From: Fiona Fitzgerald <Fiona.Fitzgerald@arun.gov.uk>
Sent: 30 May 2022 11:47
To: Planning.Responses <Planning.Responses@arun.gov.uk>
Cc: David Easton <David.Easton@arun.gov.uk>
Subject: WA/34/22/DOC

With regard to discharge of Condition 2 of WA/48/19/RES, please could the applicant confirm:

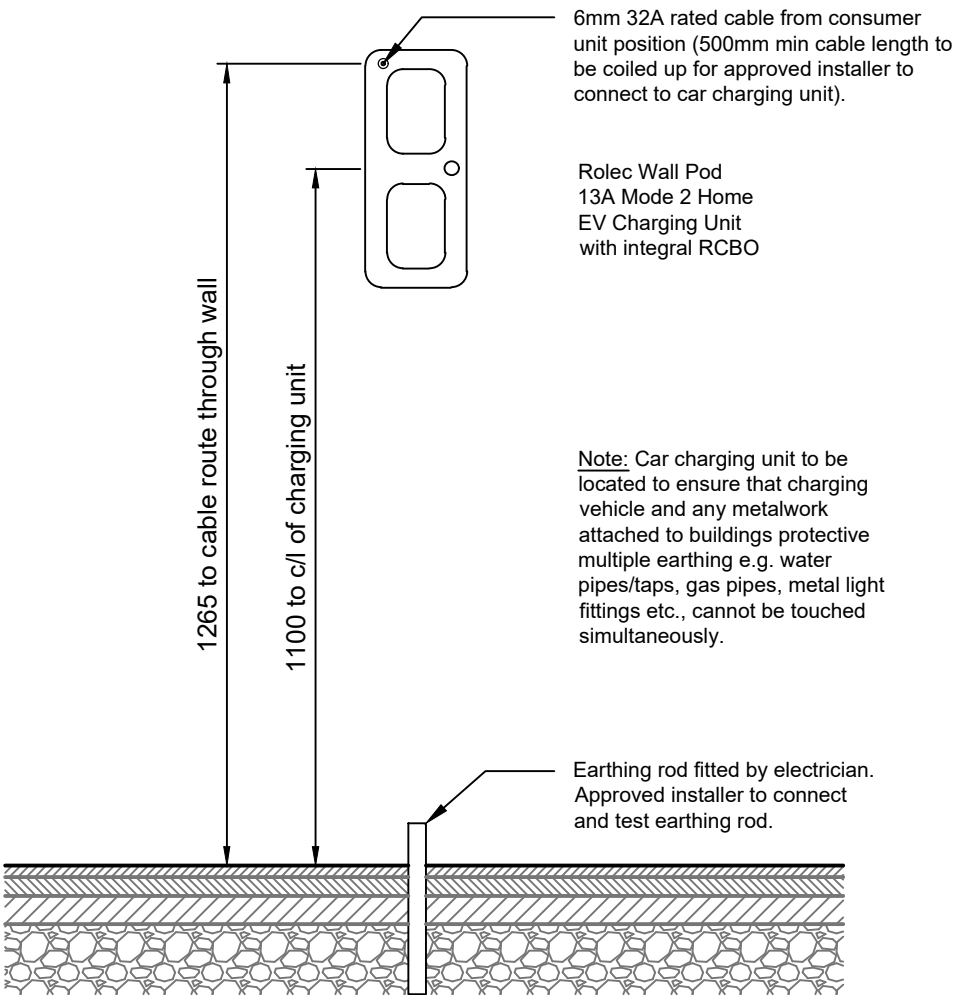
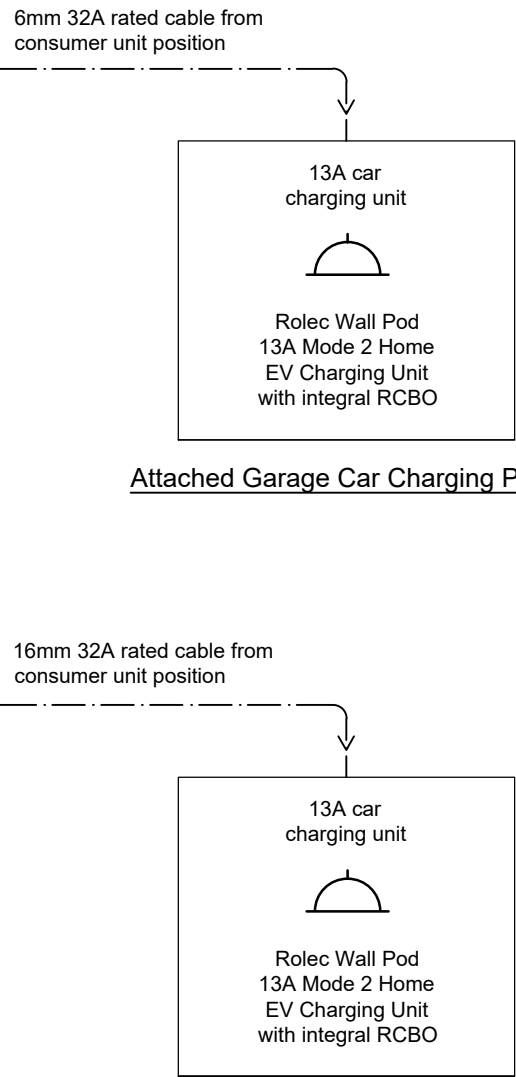
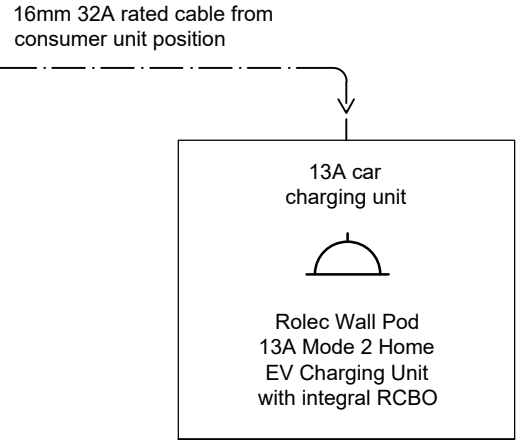
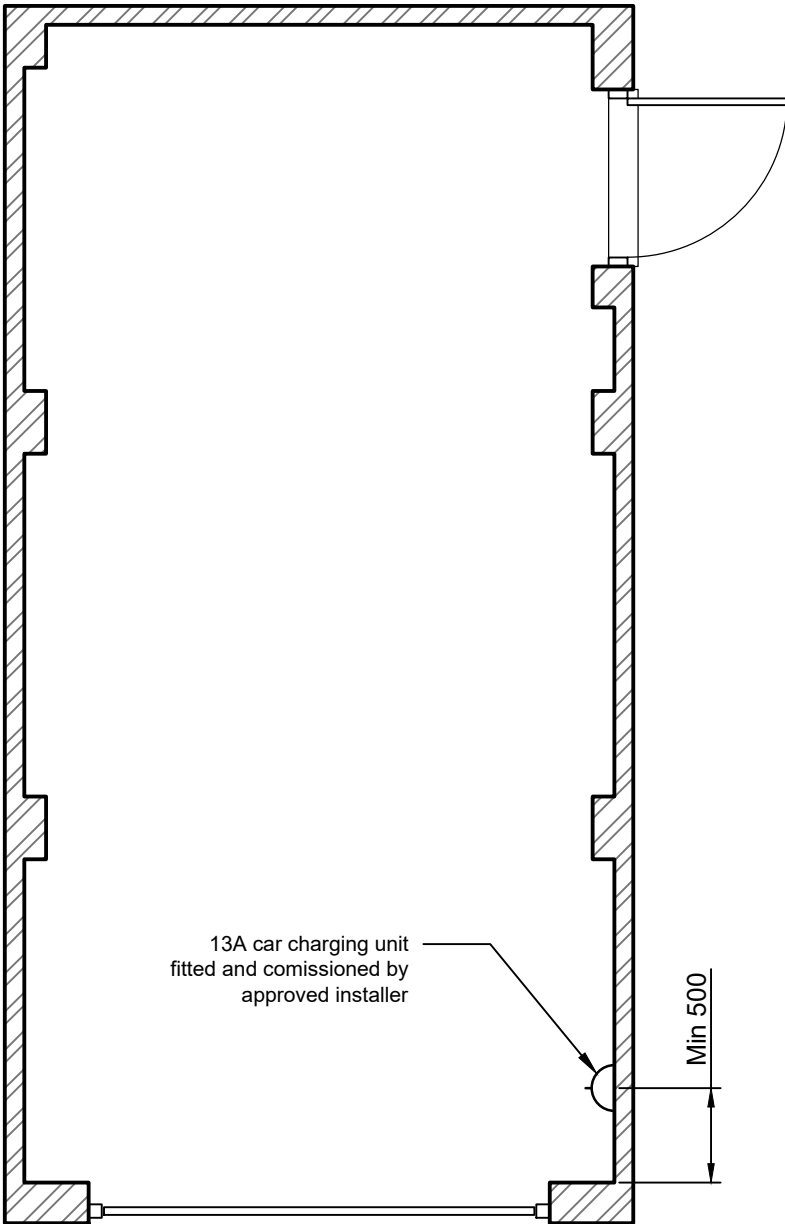
1. That 100% of the houses with a driveway or a garage have an active EV charging point.
2. That 30% of parking spaces for all other developments have an active EV charging point.

3. The specific numbers of parking spaces that 1 and 2 refer to (i.e. number of dwellings)
4. That the proposed EV charging points meet all the following requirements:

- a. Be designed and installed as described in BS EN 61851.
 - b. Have a minimum nominal rated output of 7kW.
 - c. Be fitted with a universal socket (also known as an untethered electric vehicle charge point). Alternatively, in exceptional circumstances, such as for a self-build property, if the vehicle requirements are already known, a tethered electric vehicle charge point may be acceptable.

- d. Be fitted with an indicator to show the equipment's charging status that uses lights, or a visual display.
 - e. Be a minimum of a Mode 3 specialised system for electric vehicle charging running from a dedicated circuit, or equivalent, as defined in BS EN IEC 61851-1.

- f. The requirements of BS 7671.
 - g. The requirements in the IET's Code of Practice: Electric Vehicle Charging Equipment Installation.
